NSW Department of Climate Change, Energy, the Environment and Water

Our ref: OUT25/7833

**Subject: Warnervale Shopping Centre, 262 Hakone Road, Warnervale (MP10_0195-MOD-2) -
Response to Submissions (RTS)**

Detailed advice to DPHI Planning & Assessment regarding the Warnervale Shopping Centre, 262 Hakone Road, Warnervale (MP10_0195-MOD-2) - Response to Submissions (RTS)

1 EXCAVATION PLAN
1:2500

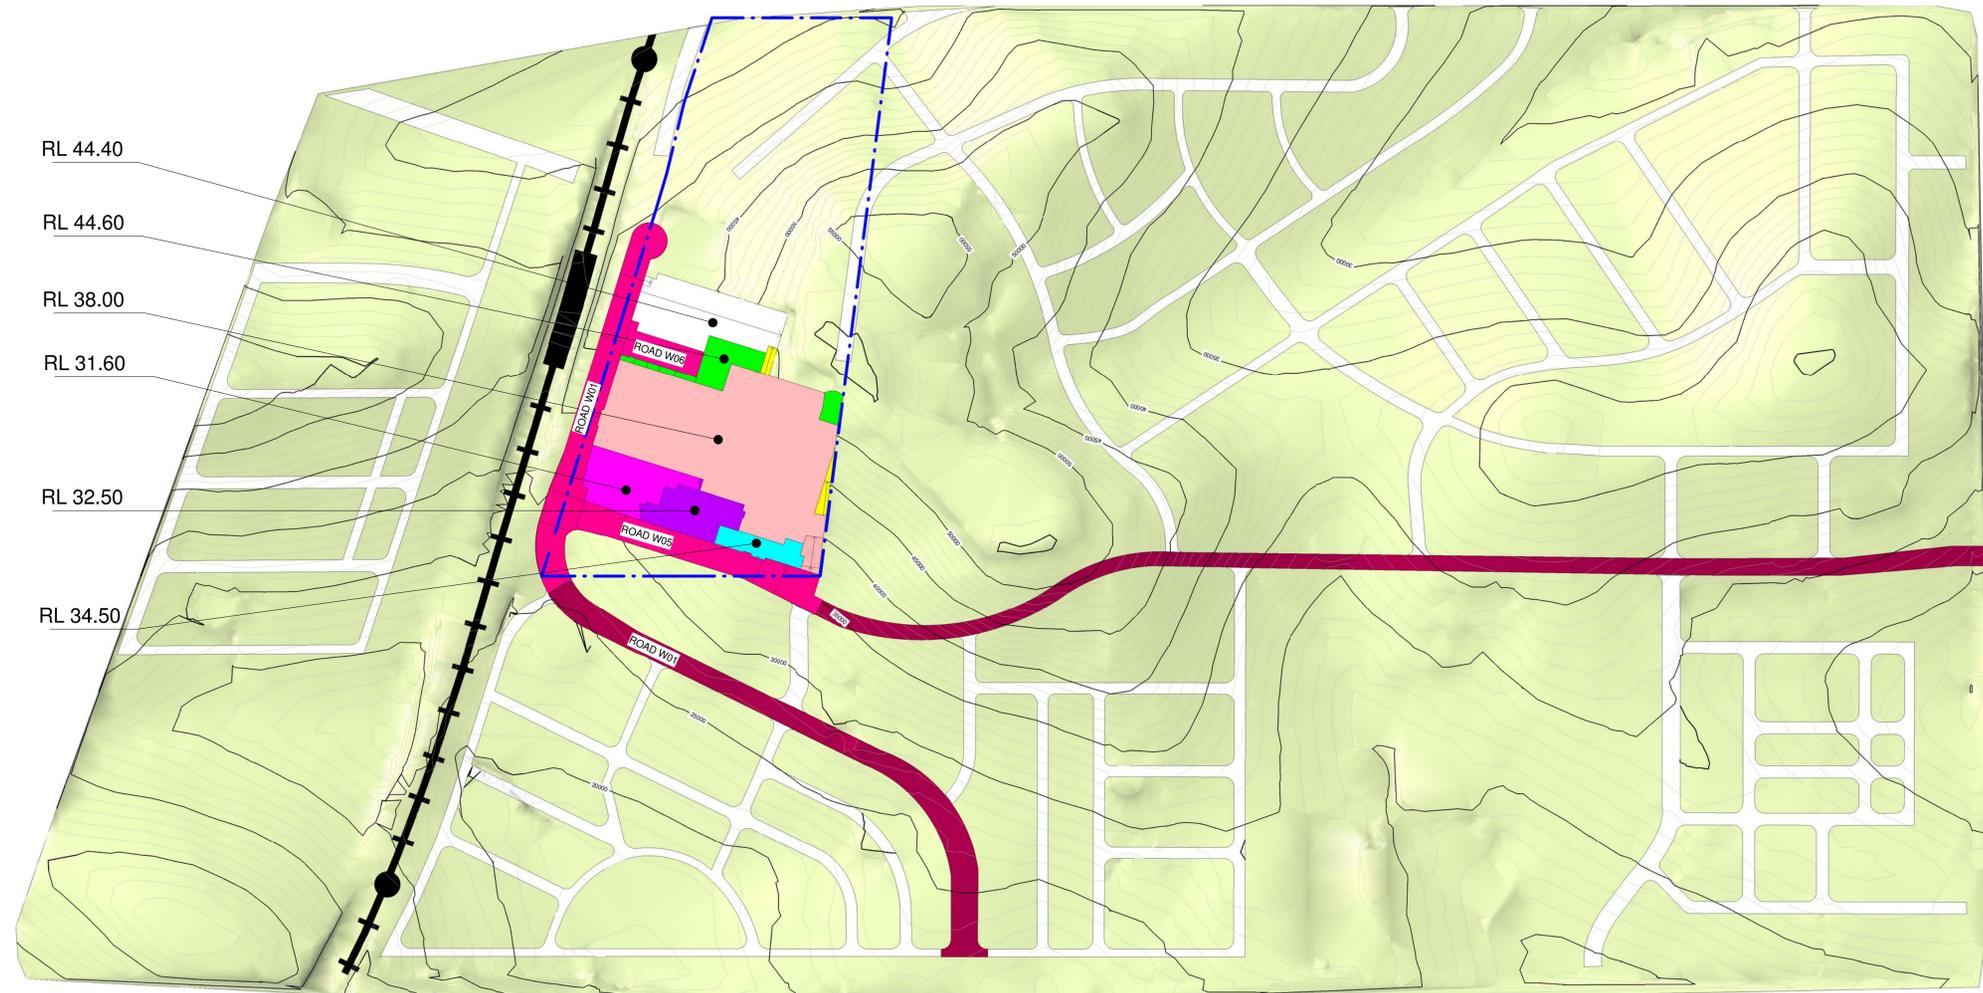
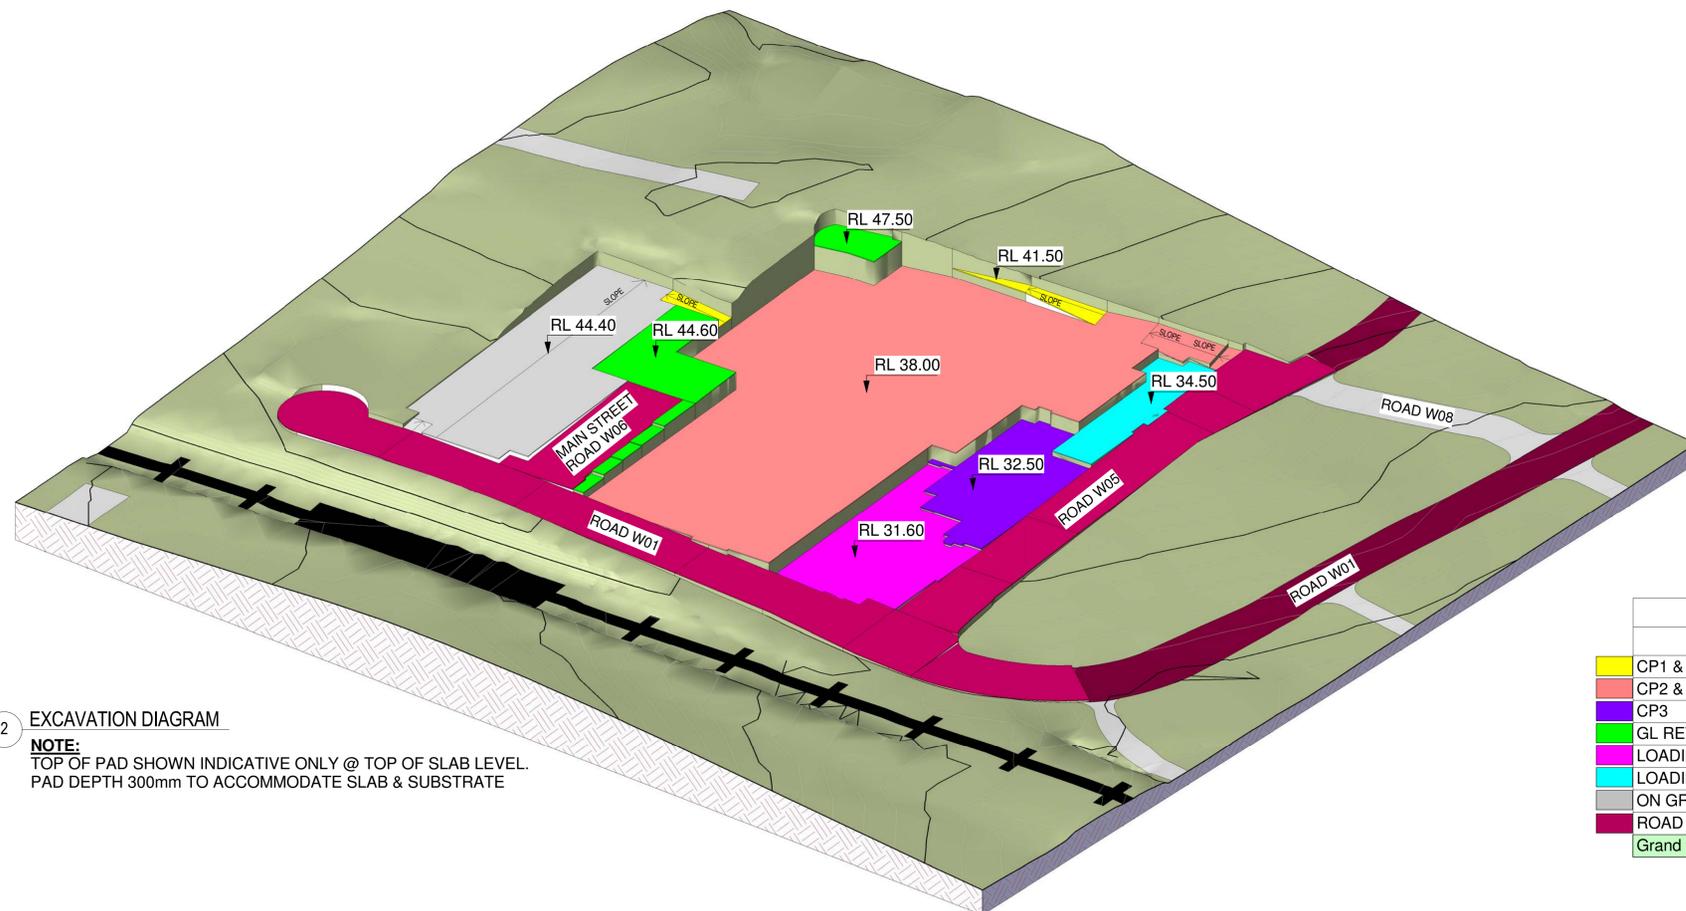
The Department of Planning, Housing and Infrastructure (DPHI) should seek from the proponent the maximum annual volume of water take due to aquifer interference activities and demonstration of the ability to acquire sufficient water entitlement unless an exemption applies.

Insufficient information is provided in the RTS to determine whether groundwater will be intercepted. The proponent indicates that the groundwater level is estimated to be 3m below surface level and that groundwater was not encountered in investigative boreholes that extended to a maximum depth of 4.9 mBGL. The excavation levels shown in the Civil Engineering – Bulk Earthworks and Architectural Section Plans show excavation for the construction of retaining walls will extend to depths of over 10m. Confirmation if groundwater will be intercepted is requested.

As per Recommendation 1.1 above, the EIS has not provided a volumetric quantification of groundwater take. Additionally, the EIS has not provided an assessment of impacts to groundwater due to construction or operation of the project. NSW DCCEEW Water Group notes that without groundwater take estimations it is difficult to assess the level of risk. Therefore, the proponent should determine the estimated take volume.

If the take of groundwater is found to be greater than 3 ML per year, DPHI should seek from the proponent an assessment of impacts due to aquifer interference activities in accordance with the NSW Aquifer Interference Policy and framework (2012). These documents are available at:
